27 April 2018

RE: Response to Department of Planning and Environment Request for Response to Submissions (SSD 8440) at 42 Honeysuckle Drive, Newcastle 2300
REF: 17058

The proposal has a variety of communal spaces accessible to the public, residents and guests.

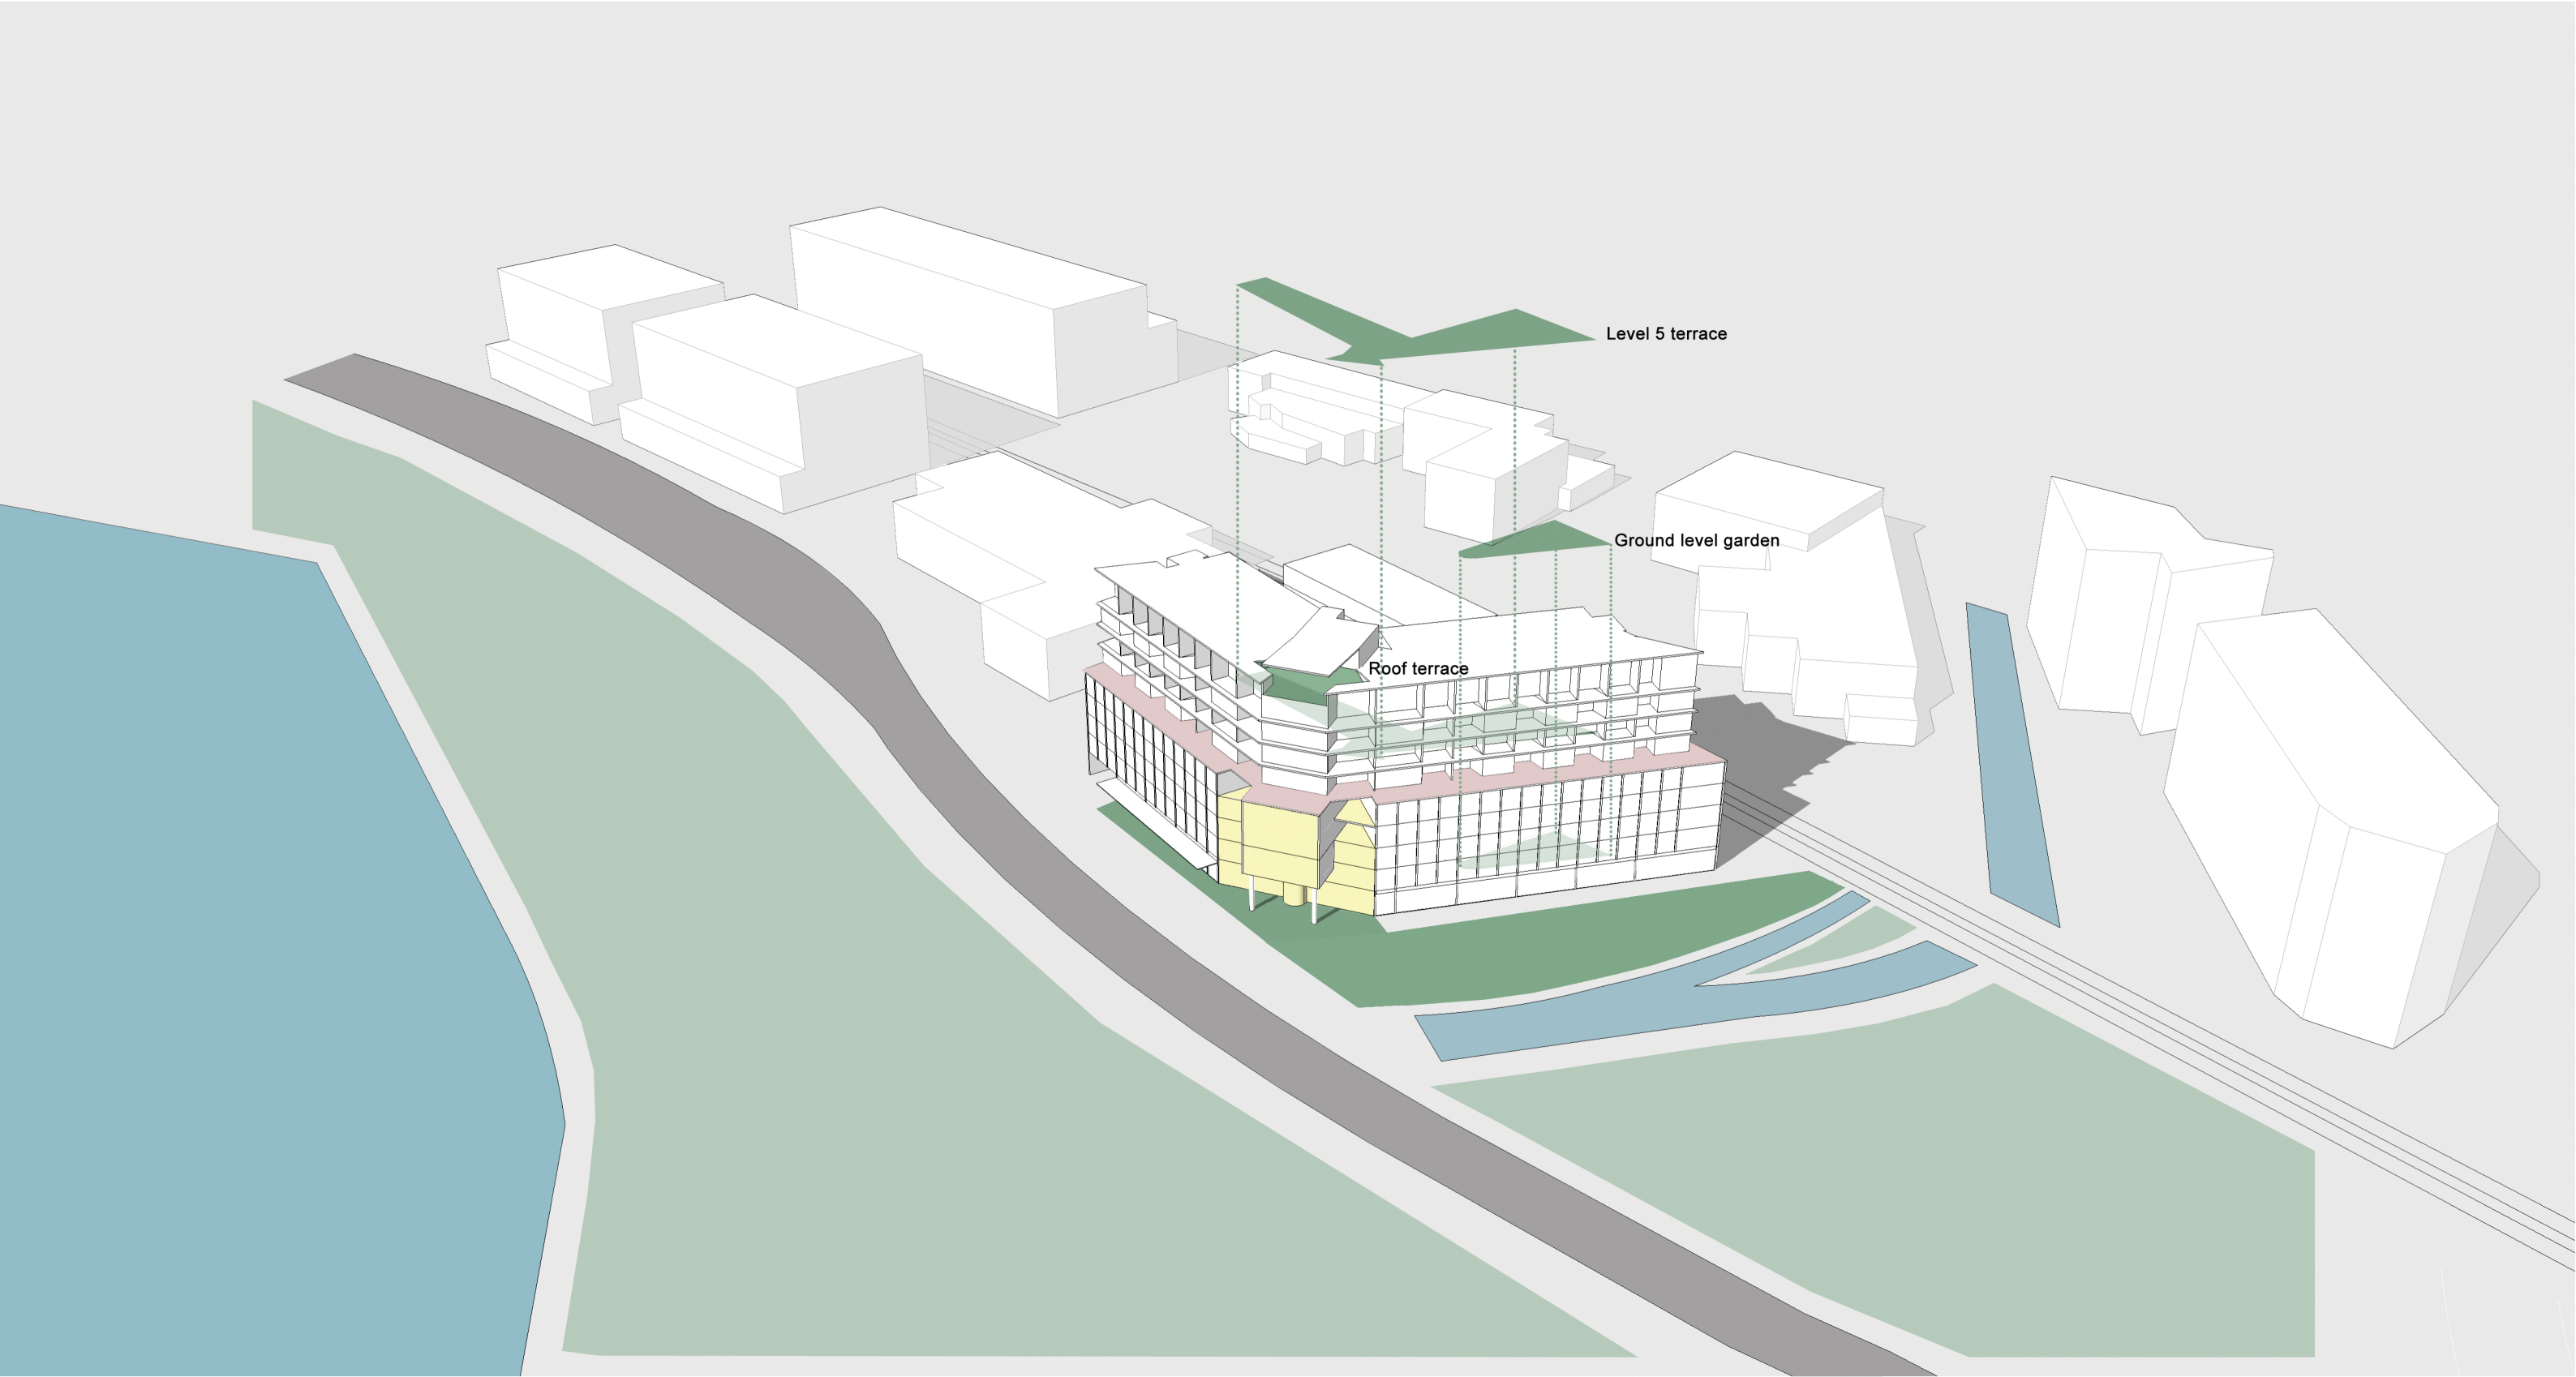
- *Provide amended plans / additional information which confirms:*
 - *The area of communal open space provided, including whether residents are also given access to hotel facilities including the gym and library / lounge*
 - *The amount and duration of solar access to the communal open space in mid-winter*
 - *The location and total area of deep soil zones*
 - *The location and area of the storage cages for each dwelling type, including both internal and external storage space*
 - *That 20% of apartments will meet the Liveable Housing Guidelines, including plans showing pre and post adaptable layouts.*

- As shown on the plans in Attachment C, the communal courtyard/open space will have an approximate area of 500m² which equates to 13% of the site area. The hotel facilities including the gym library and lounge will not be accessible for residents.
- Sufficient solar access is provided to the communal open space area during mid-winter. Diagrams demonstrating this can be found in section 3.2 of Attachment D.
- The total area of deep soil zones is 385m² which equates to 10.3% of the site. Refer to section 3.3 of Attachment D for the plan showing the areas of the deep soil zones.
- 20% of the apartments achieve Silver level design guidelines with the exception of core item 6. Further details and plans showing pre and post adaptable layouts can be found in section 2.5 of Attachment D.

Shadow Diagrams Winter Solstice
June 21

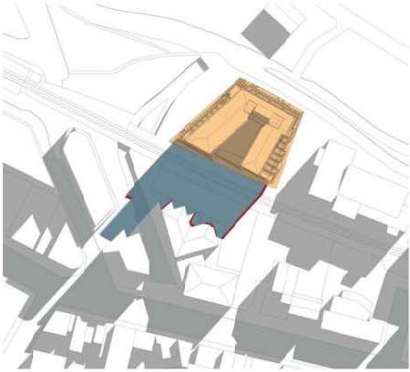
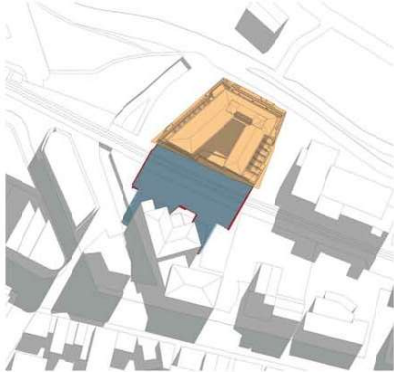
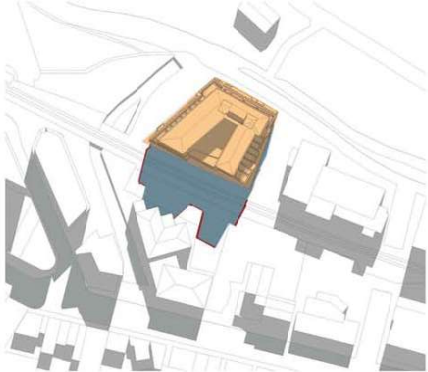
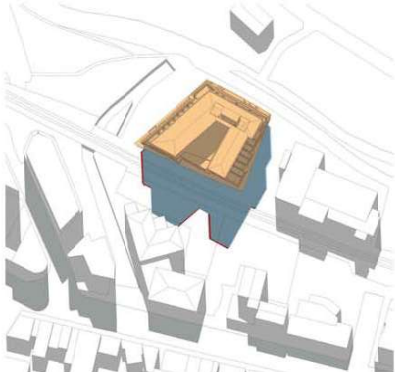
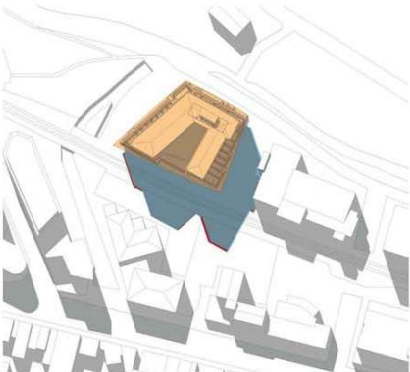
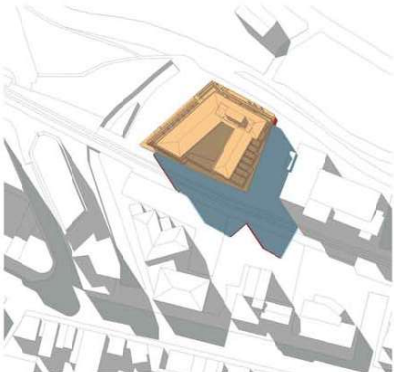
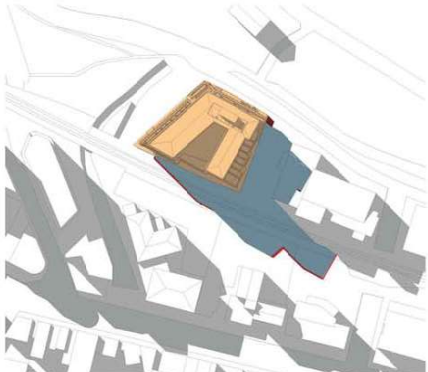
- *Provide revised overshadowing diagrams which clearly show a comparison between the proposed portions of the building which exceed the 30m height standard and a fully compliant building.*

Revised overshadowing diagrams have been prepared and are provided within the architectural drawing set which can be found in Attachment C. Further demonstration of this is also shown in the report prepared by Batesmart in Attachment D. The shadow diagrams now show the minor impacts caused as a result of the building portions which exceed 30m in height in comparison to a building that is only 30m in height.
